23 January 2018

Re: Hume Coal Project and Berrima Rail Project - Noise and Vibration Assessment, Response to Independent Noise Advice dated 4 December 2017

## Non-network rail noise - existing users

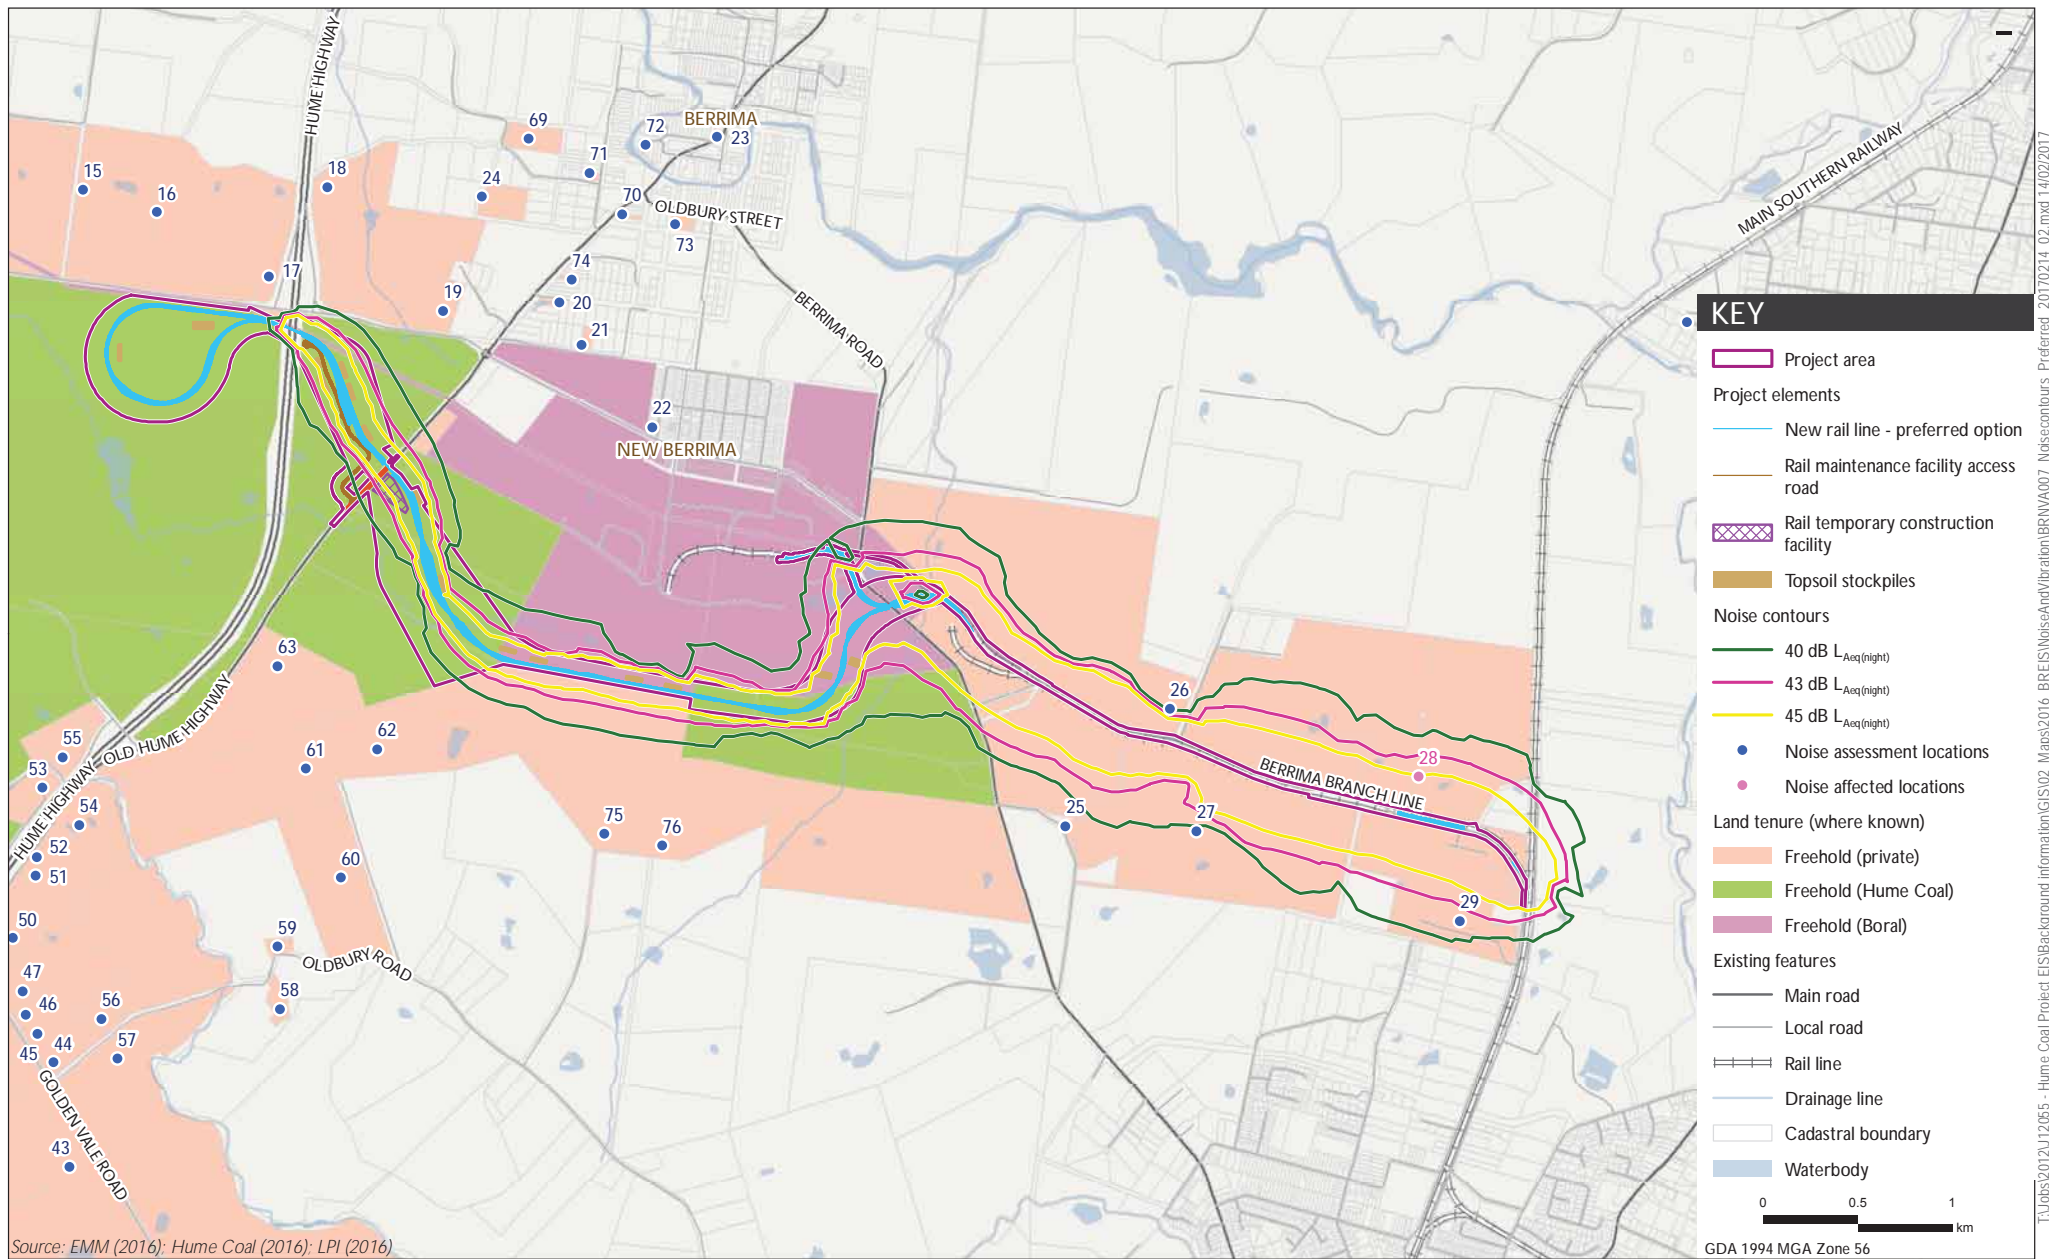
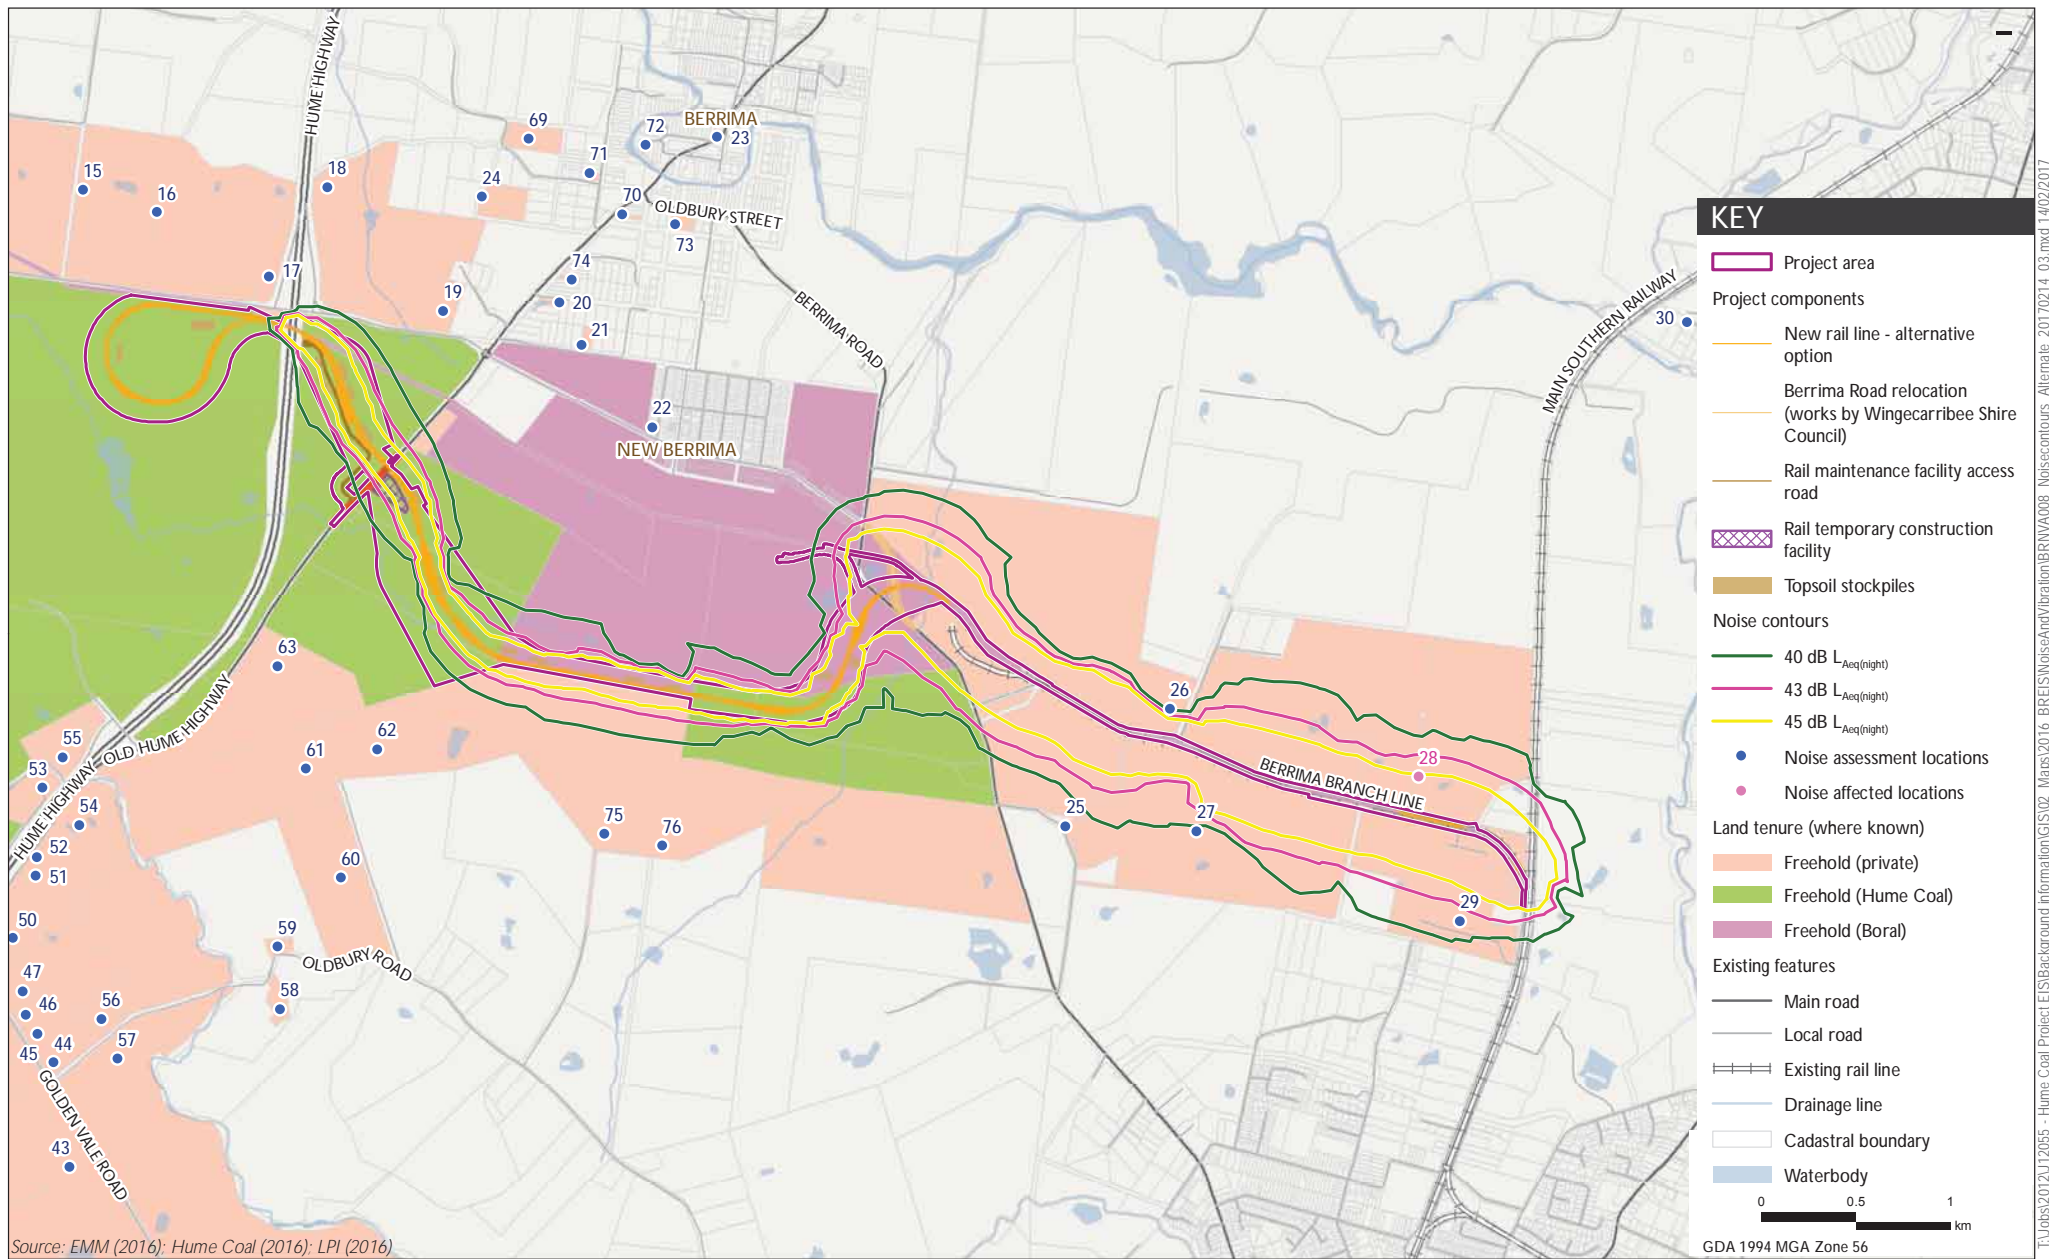
The assessment locations 28 and 29, referenced by the reviewer, are currently exposed to the rail operations of existing industrial facilities in this area of track. It is therefore important to note that the section of curved track nearby that leads to the Berrima junction with the main rail line will not be altered as part of the Berrima Rail Project. The reference to rail wheel squeal here, if present, is therefore not a consequence of the proposed project. Moreover, location 28 is located along a straight section of track while location 29 is arguably closer to the aforementioned existing curved section.
